**RE: Kennan Properties
12900 Central Ave SE
Grading and Drainage Plan
Stamp Date: 05/15/18
Hydrology File: L22D061**

Based upon the information provided in your submittal received 05/15/2018, the Grading and Drainage Plan **is not** approved for Building Permit and Grading Permit. The following comments need to be addressed for approval of the above referenced project:

C2.1

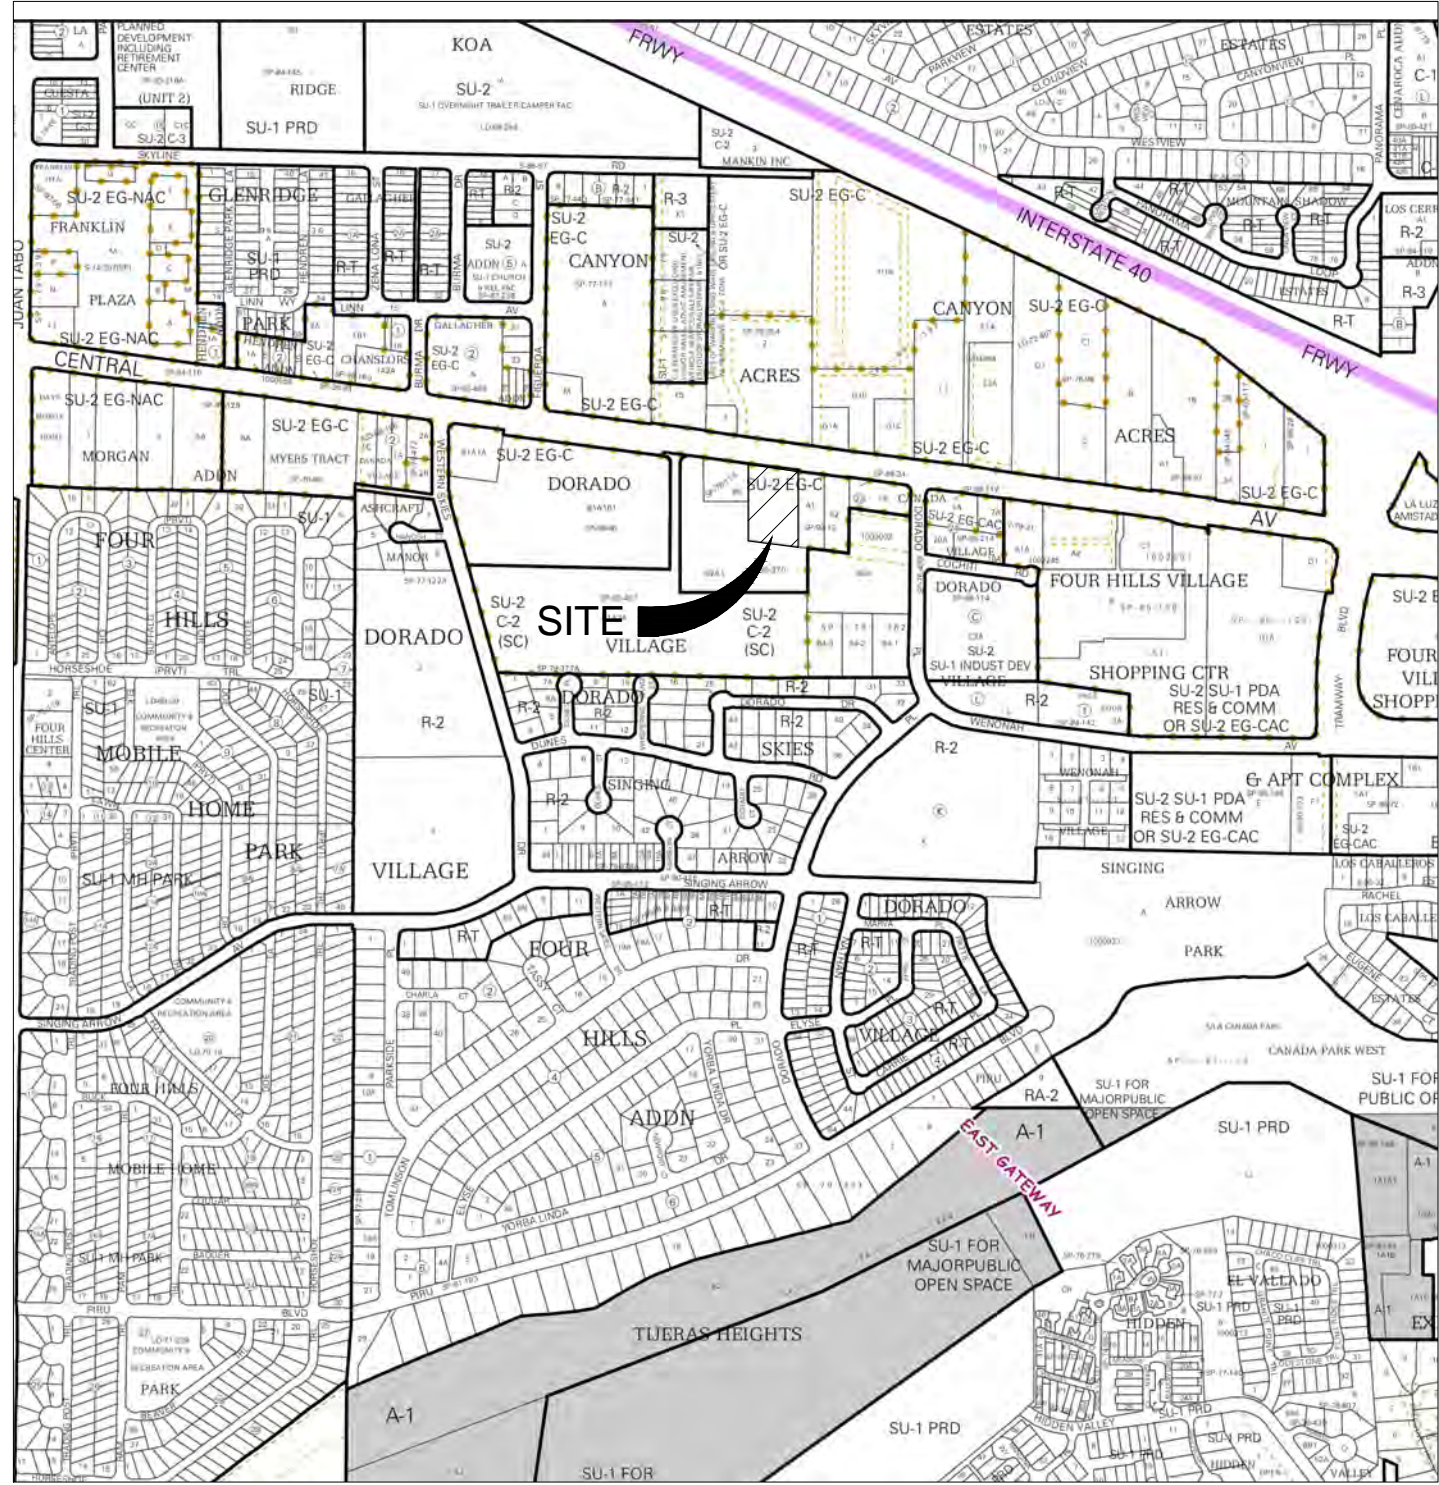
1. The site currently shows more than 1 acre of disturbance is being proposed. An Erosion and Sediment Control Plan is required and has to be submitted to the storm water quality engineer (Curtis Cherne, PE, ccherne@cabq.gov). Hydrology's approval for Grading or Building Permit will not be given until the submittal of the ESC Plan.
2. Please provide the flood plain note with effective date.
3. Please provide the benchmark information for the survey contour information provided.
4. Please provide existing flowline elevations around the existing driveway on Central.
5. Please better define the existing driveway. There appears to lines missing.
6. Please add proposed grade points at the edge of the asphalt paving and along the parking areas.
7. Please label the asphalt area and the compacted dirt area.

8. What is the shaded area around the northeast parking? It appears to be a carport. This carport needs to drain into the site.
9. It also appears that this area was excluded from the drainage calculations. Please add this area to the calculations.
10. How are you handling the off-site drainage? The site east of this project sheet flows from the adjacent parking area right into the proposed building which is lower than the adjacent property. (see photo)

11. Please provide the first flush volume elevation and the extra runoff volume storage elevation on both Pond Retaining Wall Sections.
12. Please change the precipitation zone in the Drainage Calculations from 4 to 3.
